From: Alistair Walker [REDACTED]
Sent: 28 June 2017 14:36
To: Sue Howell [REDACTED]
Cc: Anita Gardner [REDACTED] Nic Bryant
Subject: 5312_Littlehampton Leisure Centre

Following my phone call this morning, please see the link below to download the landscape softworks package for the Littlehampton Leisure Centre.

D05
5312
406
TYPICAL PLANTING DETAIL: WOODLAND MATRIX
SCALE 1 : 50

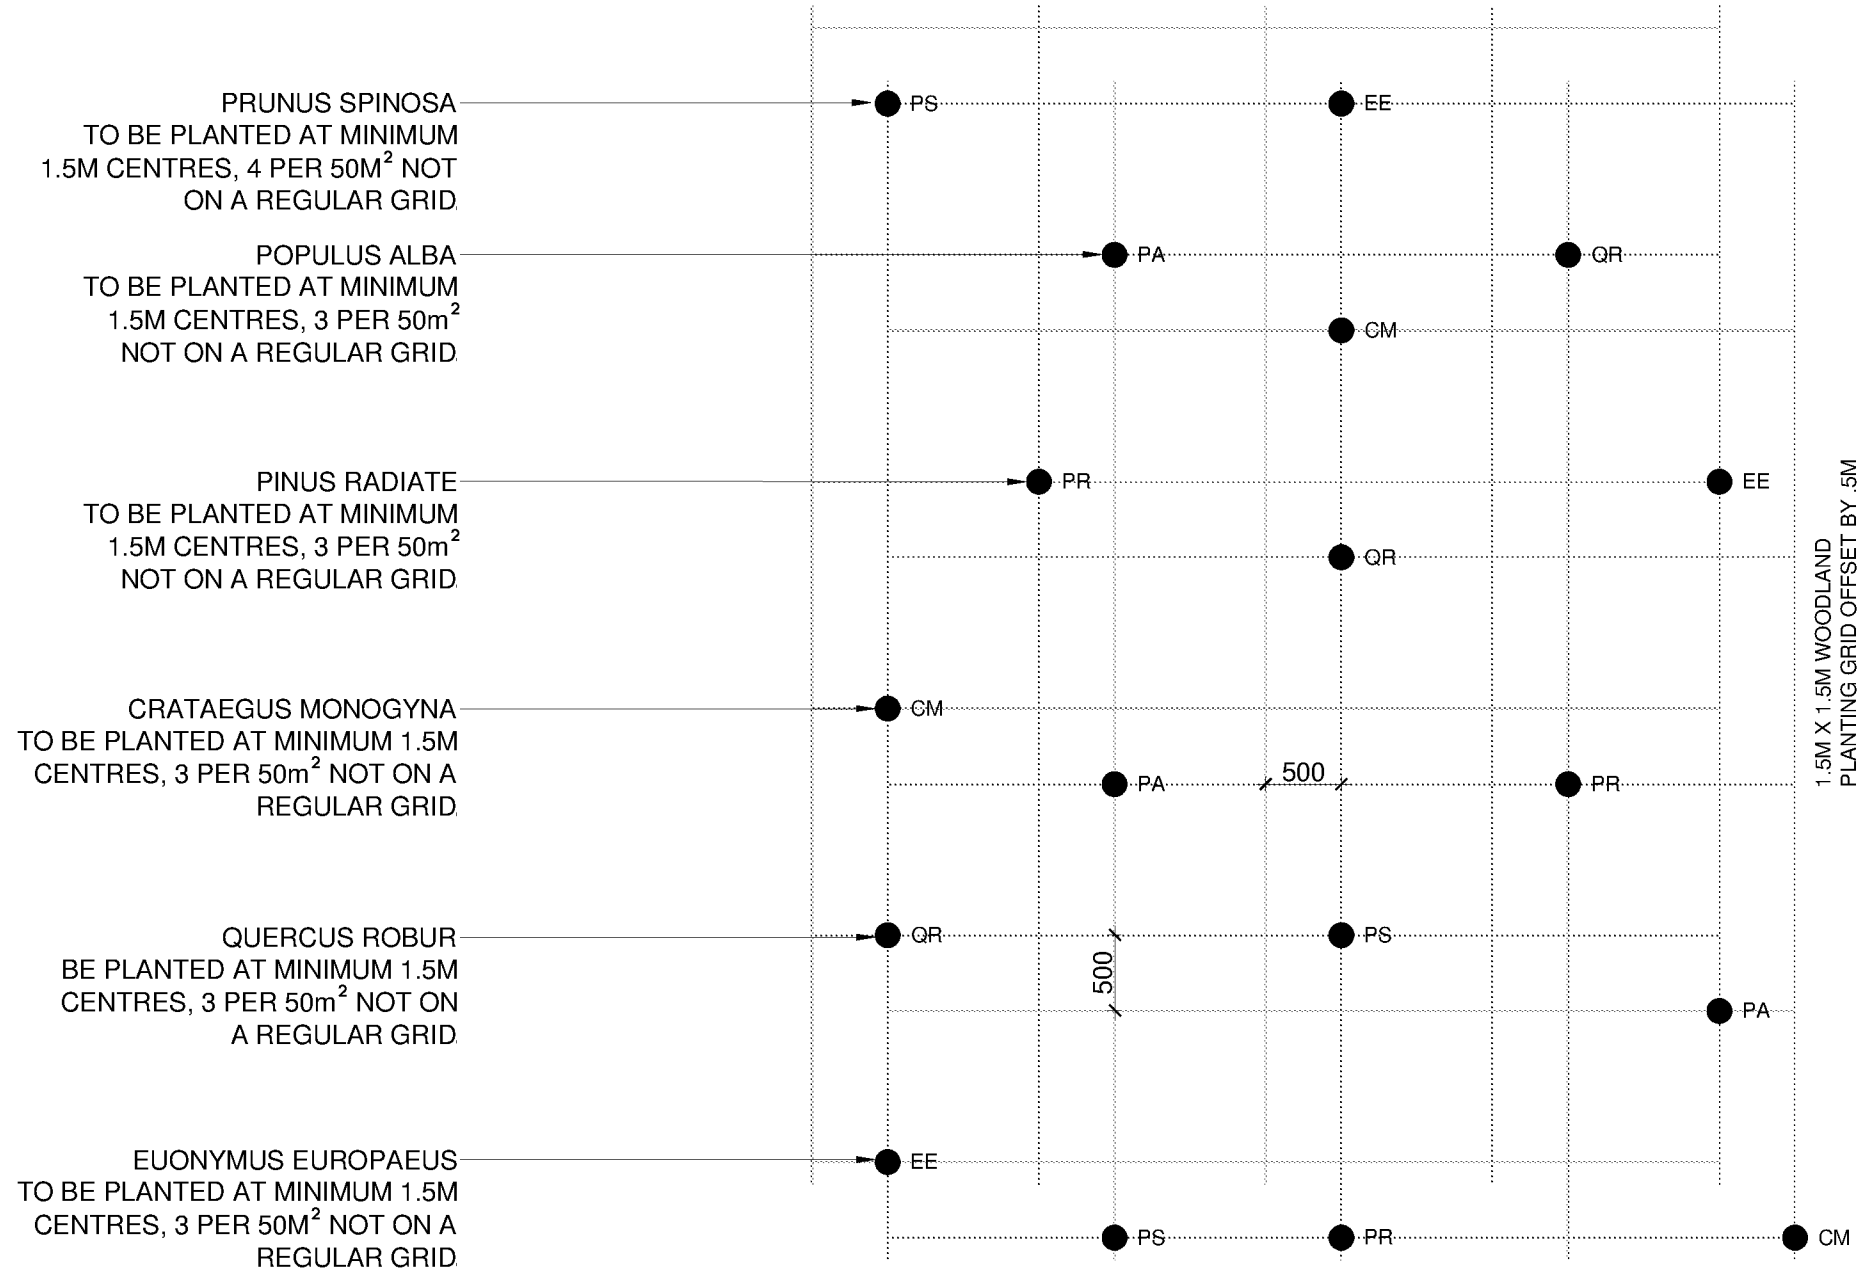
- Species rich grassland mix (EM10 – TUSSOCK MIXTURE) shown on 5312_LC_405 and also specified with 5312_LC_901 Softworks Specification.
- Compensatory woodland planting is detailed in 5312_LC_406

DWG. NO 5312_LC_401_REVb

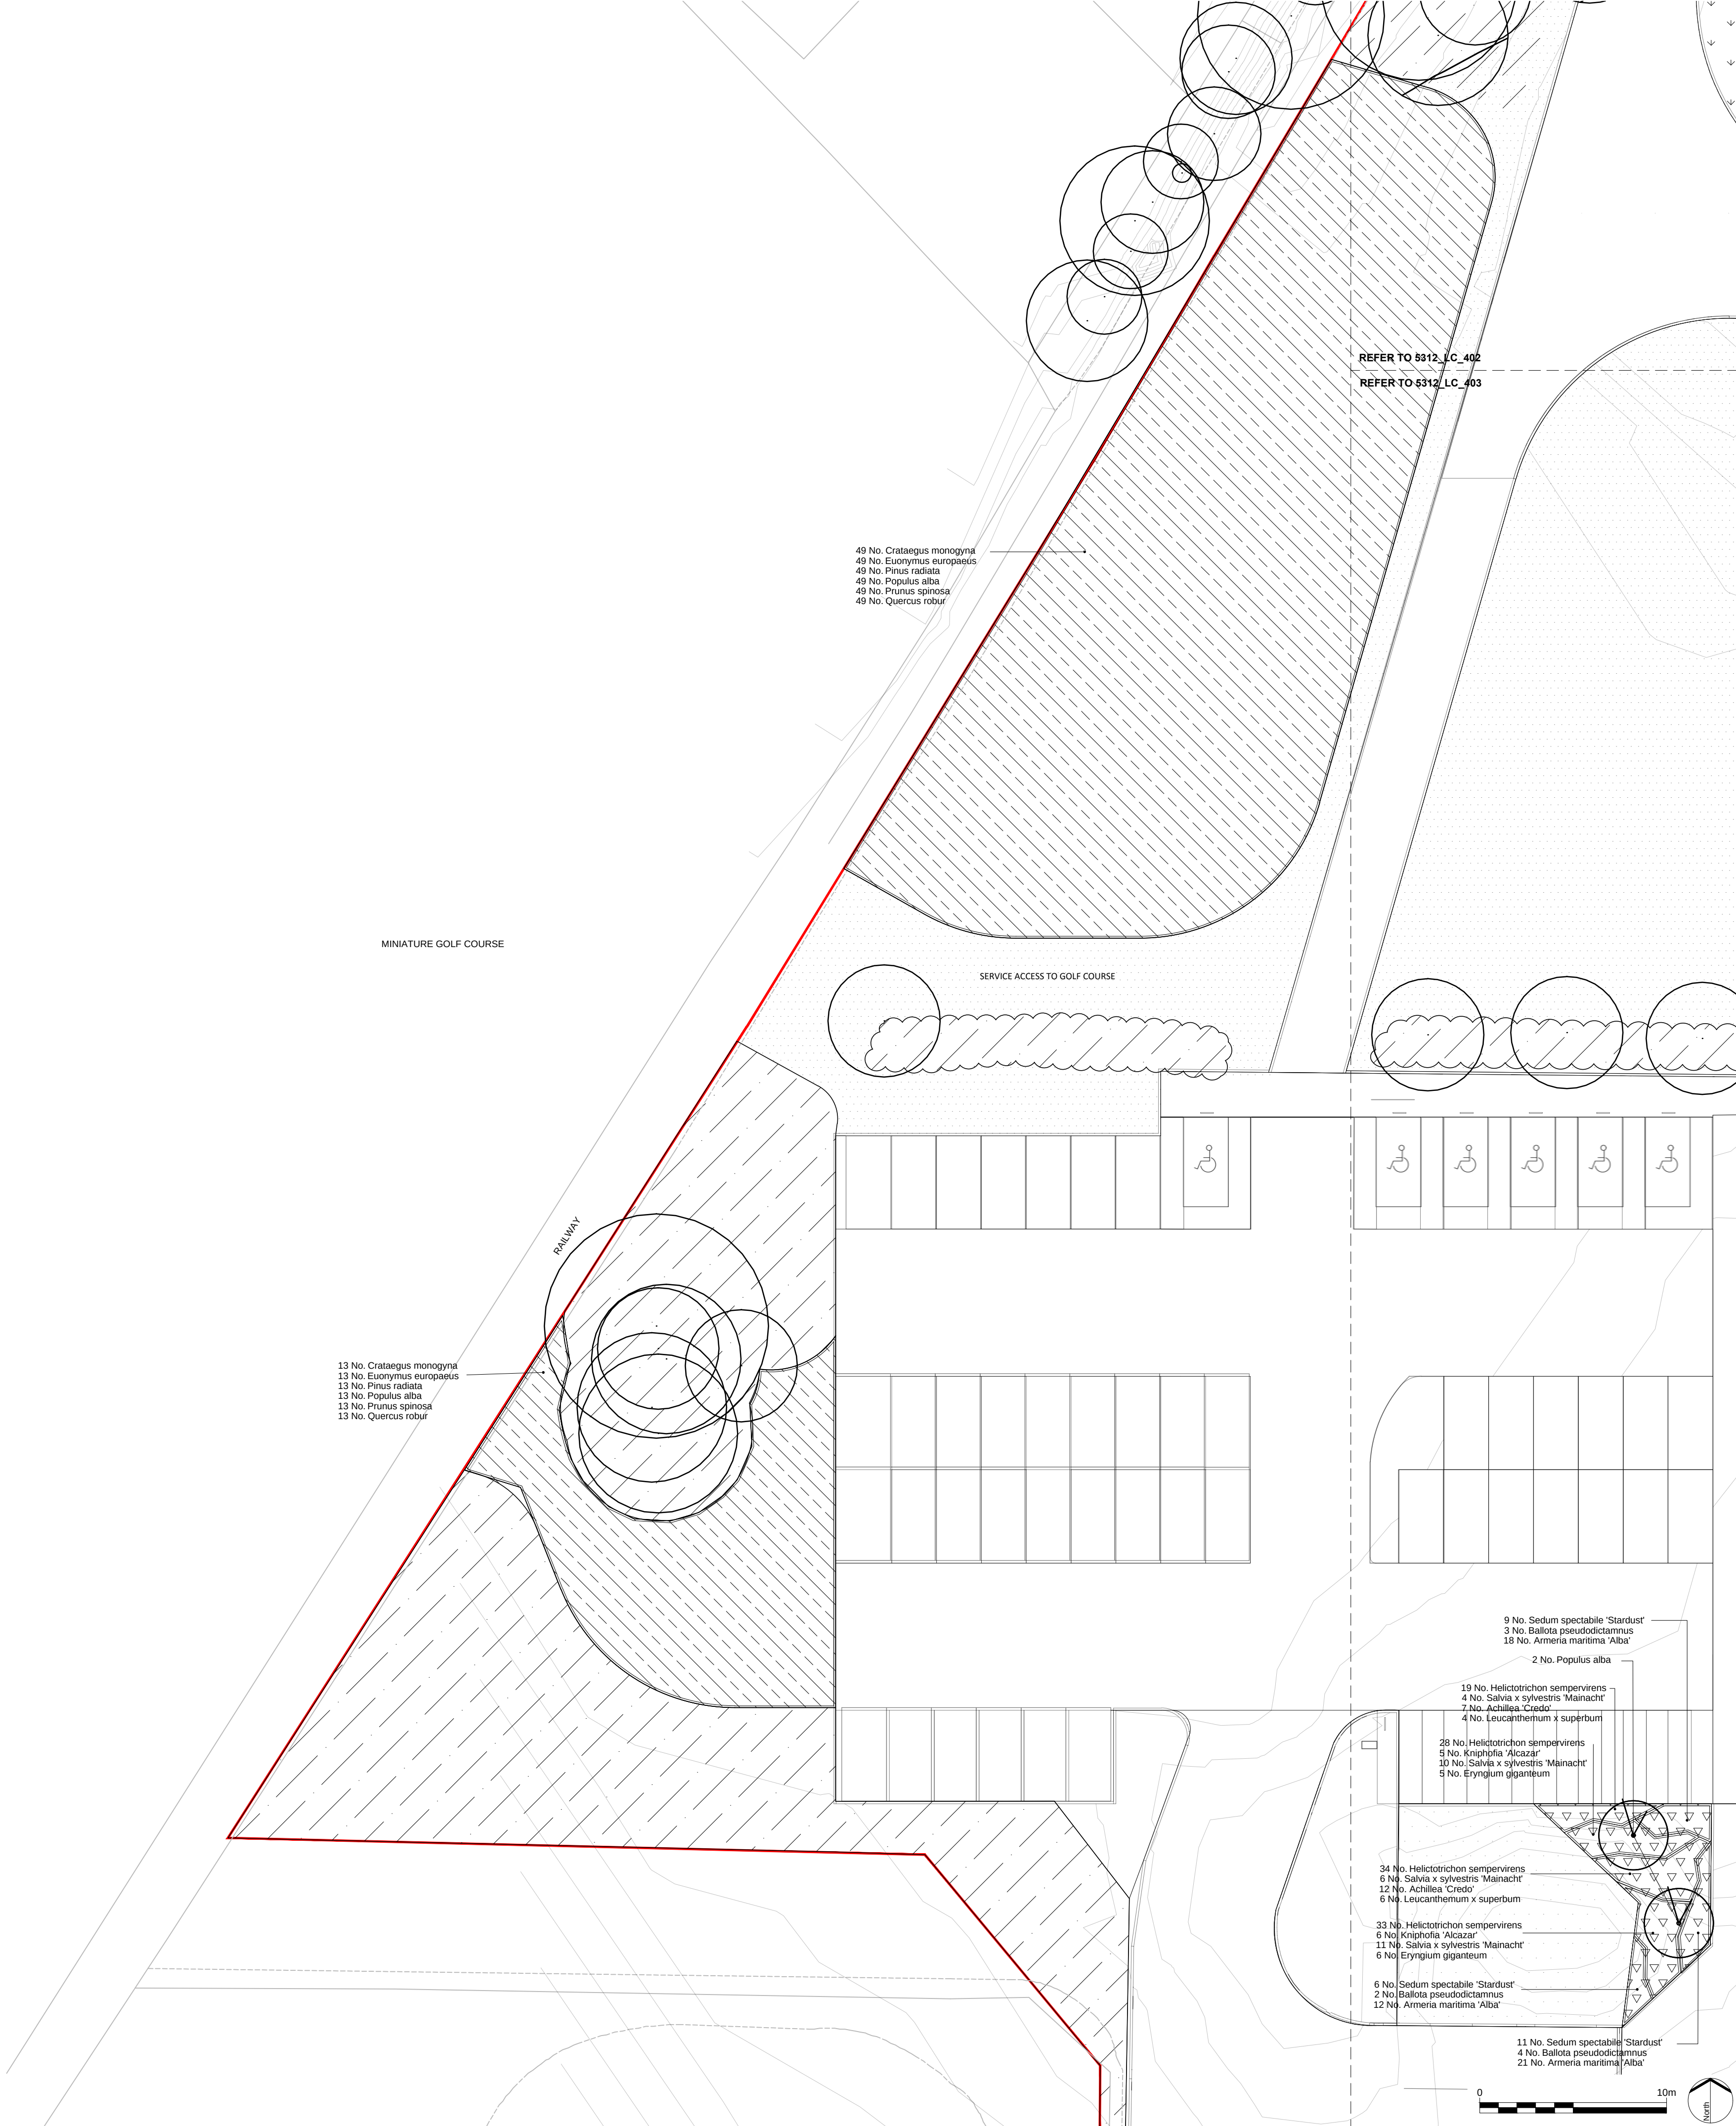
- Natural Screen Planting: We are currently specified native shrubs to be “plugged” into wildflower turf. We have used this technique successfully in the past to achieve a more natural aesthetic. Again concerns regarding future maintenance are noted and this could be changed to shrubs planted within mulch.
